Monument Glamping II:

ADDRESS:  
18045 HIGHWAY 83  
COLORADO SPRINGS, CO 80908

SITE PLAN

PROPOSED BUILDING FOOTPRINTS

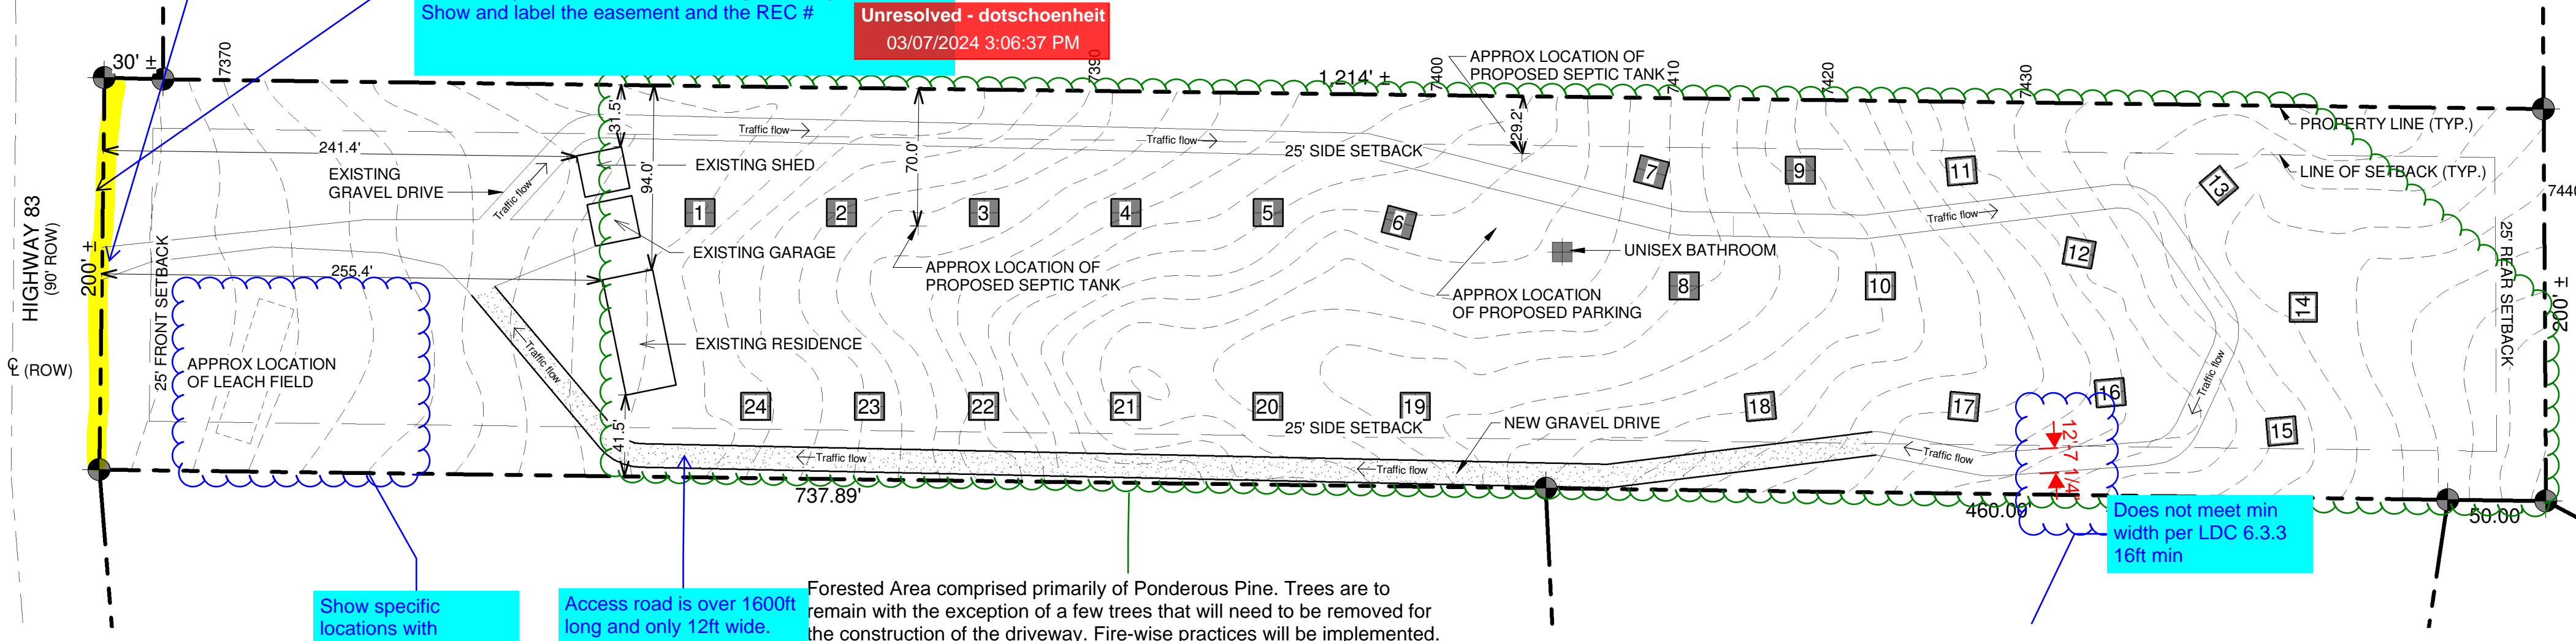
Correct based on required width

label culvert existing or proposed

Dedication of a 30-foot access easement parallel with state highway 083A shall be established and recorded with El Paso County Provide copy of recorded document pursuant to CDOT access permit requirement. Show and label the easement and the REC #

Show specific locations with setbacks. The septic plan has this level of detail. Show all current and proposed

Access road is over 1600ft long and only 12ft wide. Turn outs/Turnarounds are required. Single lane access to be min 16ft See LDC 6.3.3. and FD comments. Add DF required turnaround pts and label on SDP

label the wellhead location

Depict access road cross section design and width

RESPONSE: Revised to include a 16 foot width throughout and turnaround

RESPONSE: We will work with CDOT to establish the requested CDOT easement. The easement will be provided in association with the site development plan.

RESPONSE: Turnaround is shown between space 6 and 19. Revised to add typical driveway width of 16 feet.

RESPONSE: Provided

RESPONSE: Revised to add typical driveway width of 16 feet.
